From: Stuart Magowan [REDACTED]
Sent: 25 September 2020 11:36
To: Anita Gardner <Anita.Gardner@arun.gov.uk>; Paul Cann <Paul.Cann@arun.gov.uk>
[REDACTED]

Subject: RE: F/21/20/DOC Wicks Farm

The following link will allow a download of the drawings as noted on the attached drawing issue register together with the updated Reservoir Calculations and Management and Maintenance Plan. For ease of reference I have noted our responses in green below to the latest comments.

MANHOLE SW-06
WITH HYDROBRAKE
(Scale 1:25)

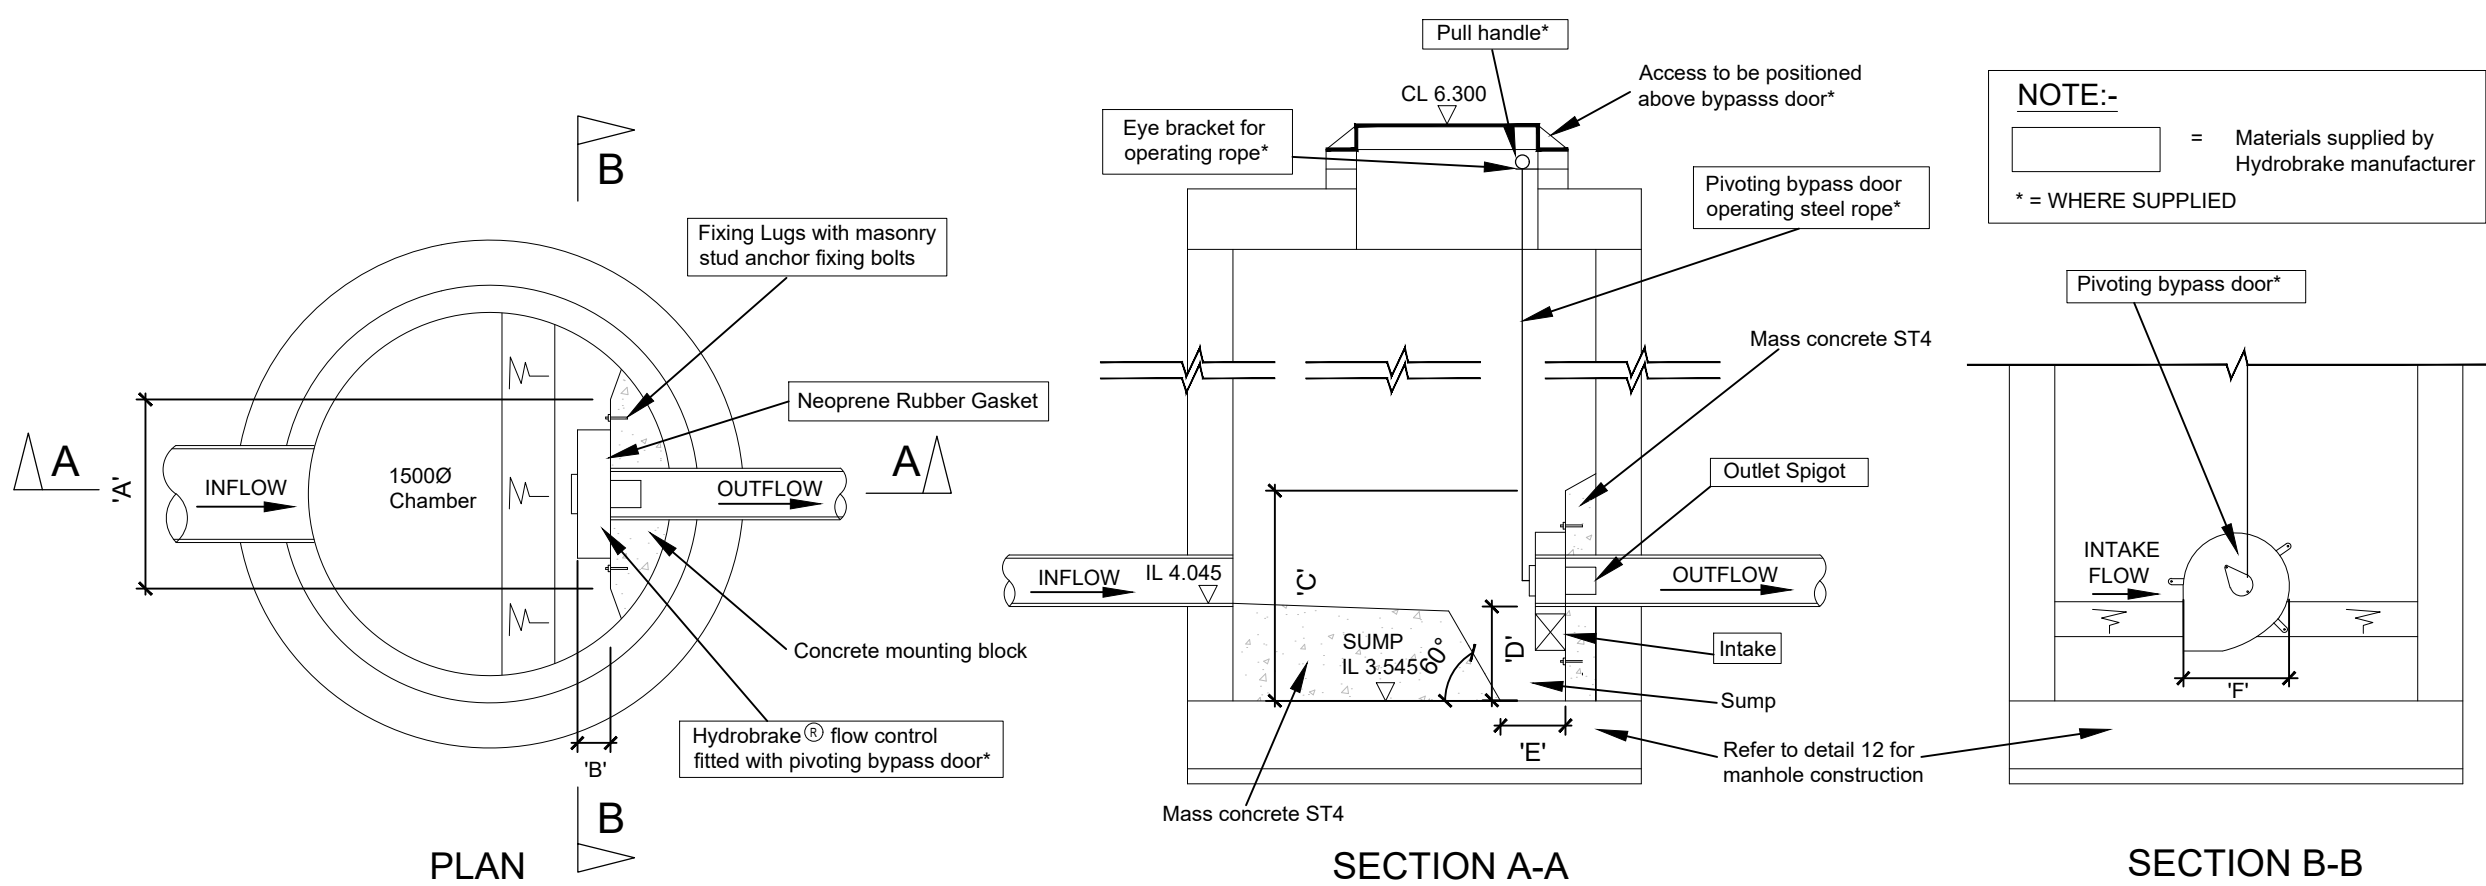
6. **Specify gradient between overflow pipe and hydrobrake chamber.** The gradient is 1 in 44 and is included on drawing 22E. ok. Noted.
7. **Provide hydrobrake chamber construction detail.** Noted and included in the link above on drawing 52B. Cover level and invert level are relevant to SW-07 – I would suggest just adding a note – ie. refer to the relevant layout drawing. Whilst the chamber construction details make reference to the details shown on 'manhole construction no.12 drawing', please specifically mention a granolithic finish to the benching. The Hydrobrake detail has been amended to say refer to layout Drawings 22 and 24 for Cover Levels, Invert Levels and Sump Levels. The note regarding the manhole construction and granolithic benching finish updated on detail also. See Drawing 52C.

17. Provide hydrobrake chamber construction detail. Noted, included in the link above on drawing 52B. See item 7 above – similar comment applies. Noted. See my response to item 7 above.

CLIENT	DPS Limited
PROJECT	Wicks Farm Polytunnel Ford
TITLE	Construction Details Sheet 3 of 3
DRAWN	P Reynolds
DATE	Aug 2020
PROJECT NO.	23210
ENGINEER	S Burgess
CHECKED	SB
DWG. NO.	53
REV.	
SCALE	As shown @ A1

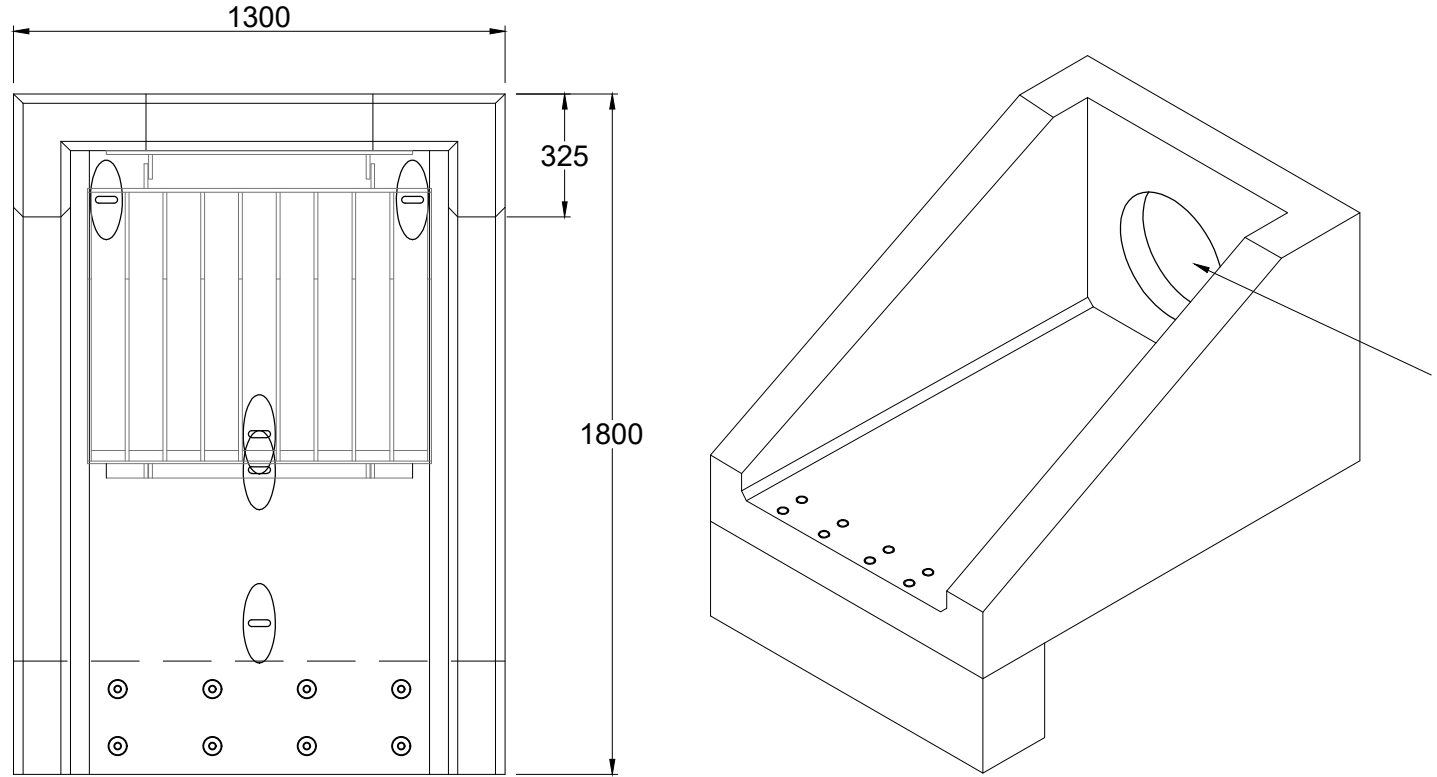
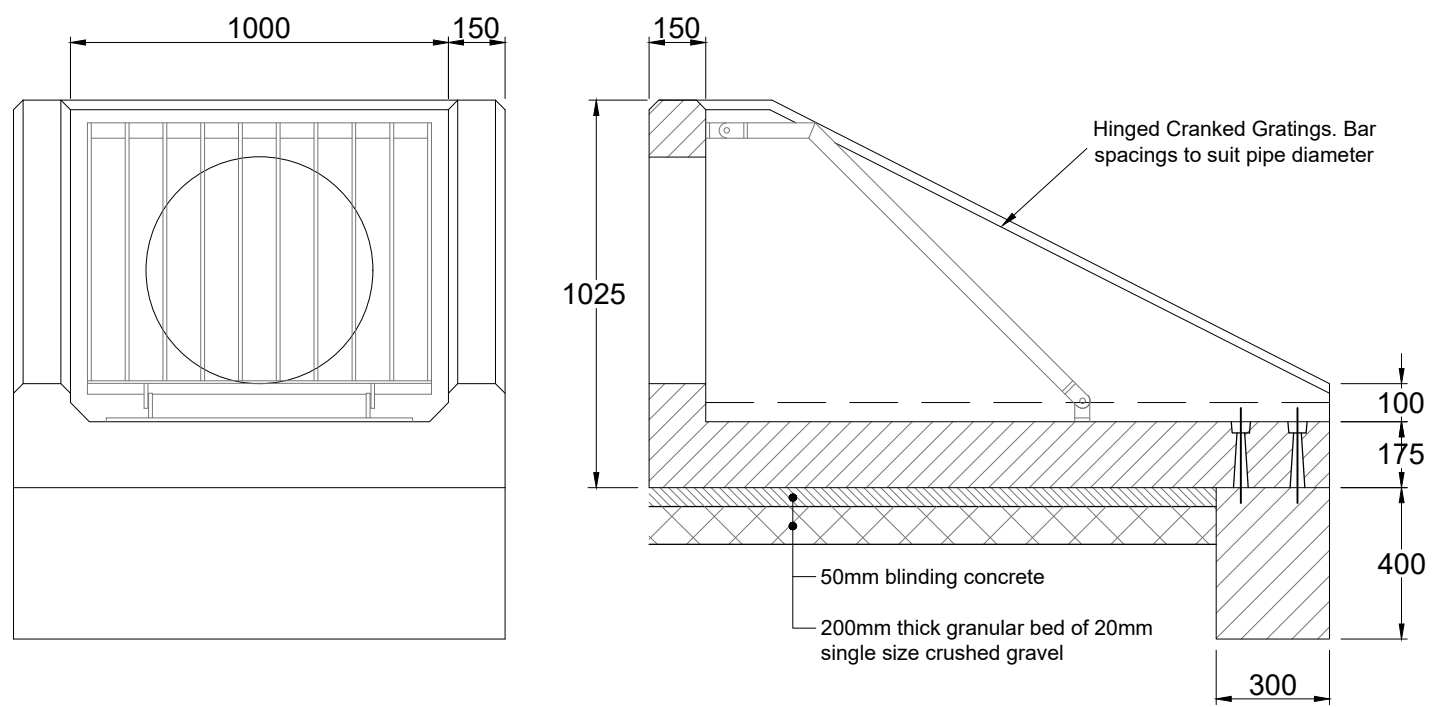
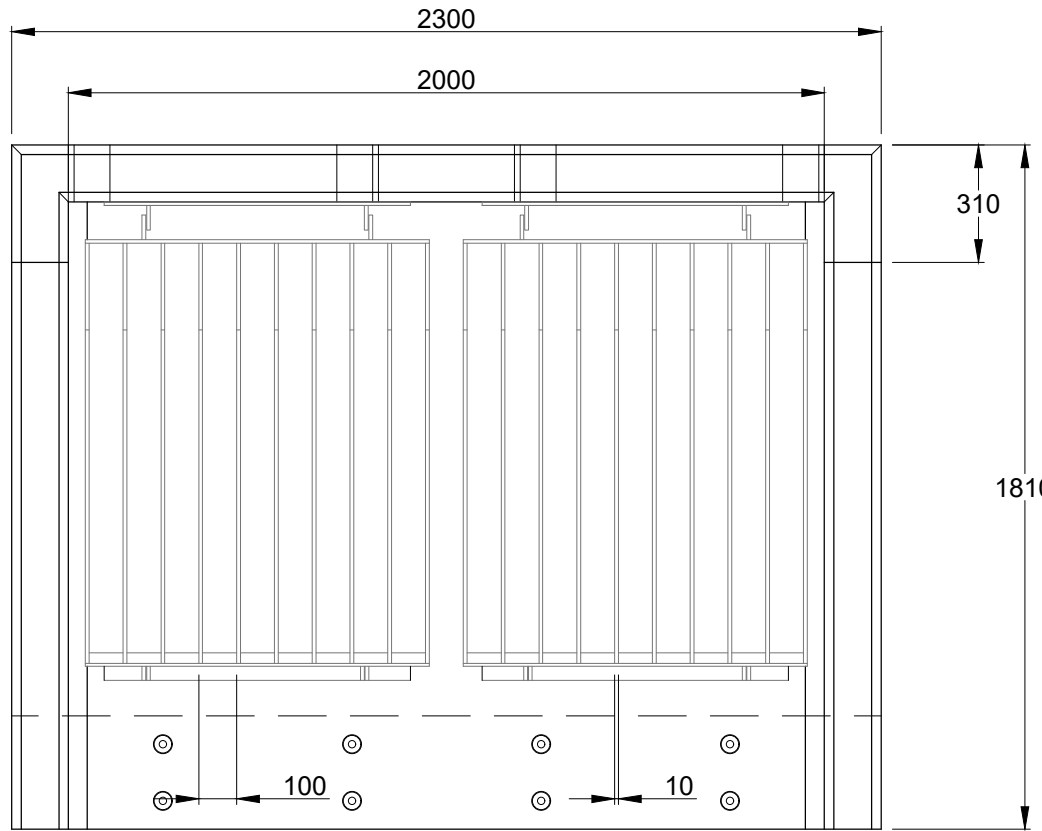
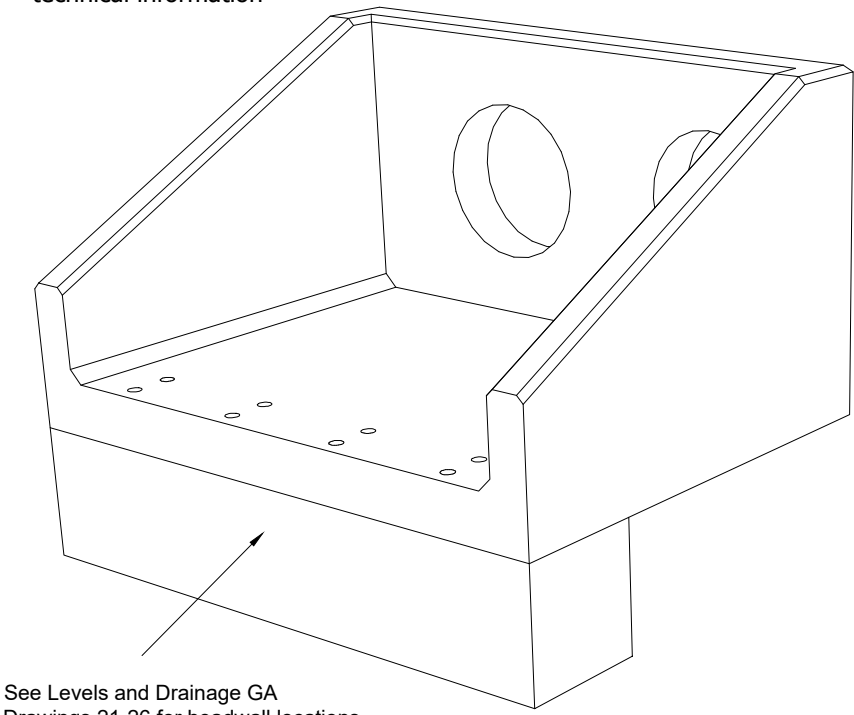
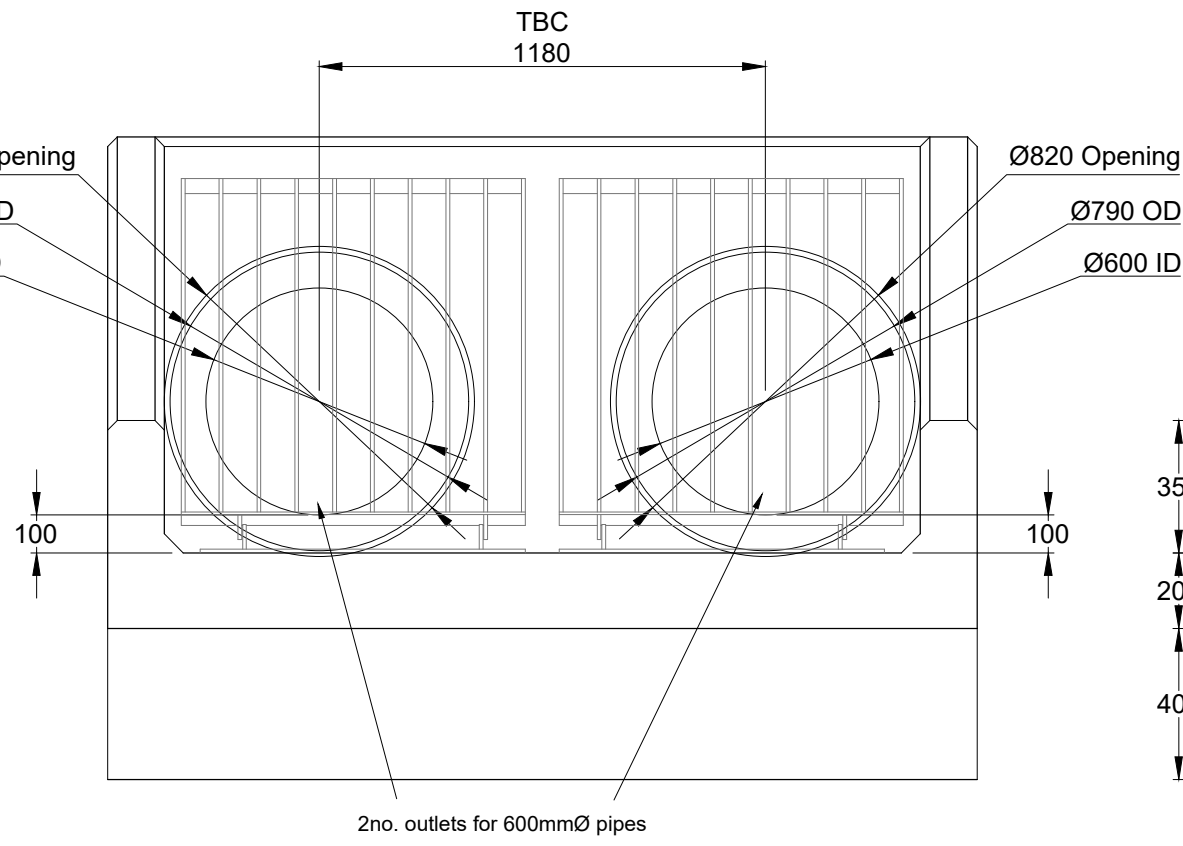
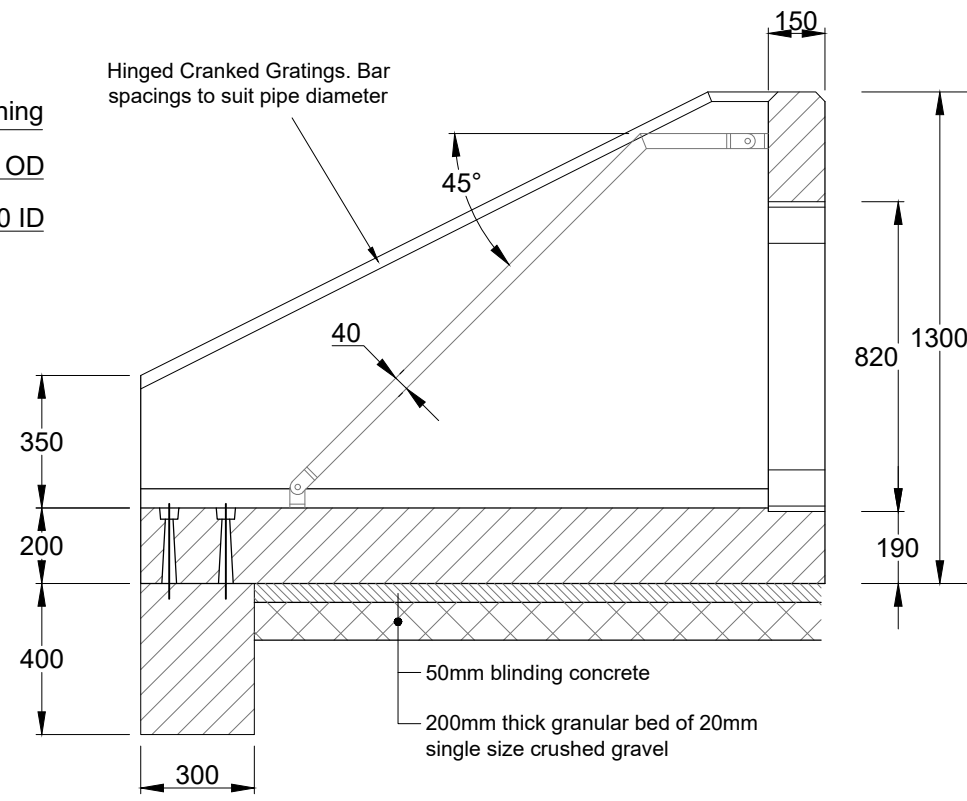
5. **Overflow pipe from reservoir provide headwall with cranked grille with bar spacings to suit 150mm diameter pipe. Include construction detail.** Detail of Althon Headwall R10CA with cranked grill and installation instructions provided on 13 July 2020 and are included in the link above on drawing 53. Ok. Noted.
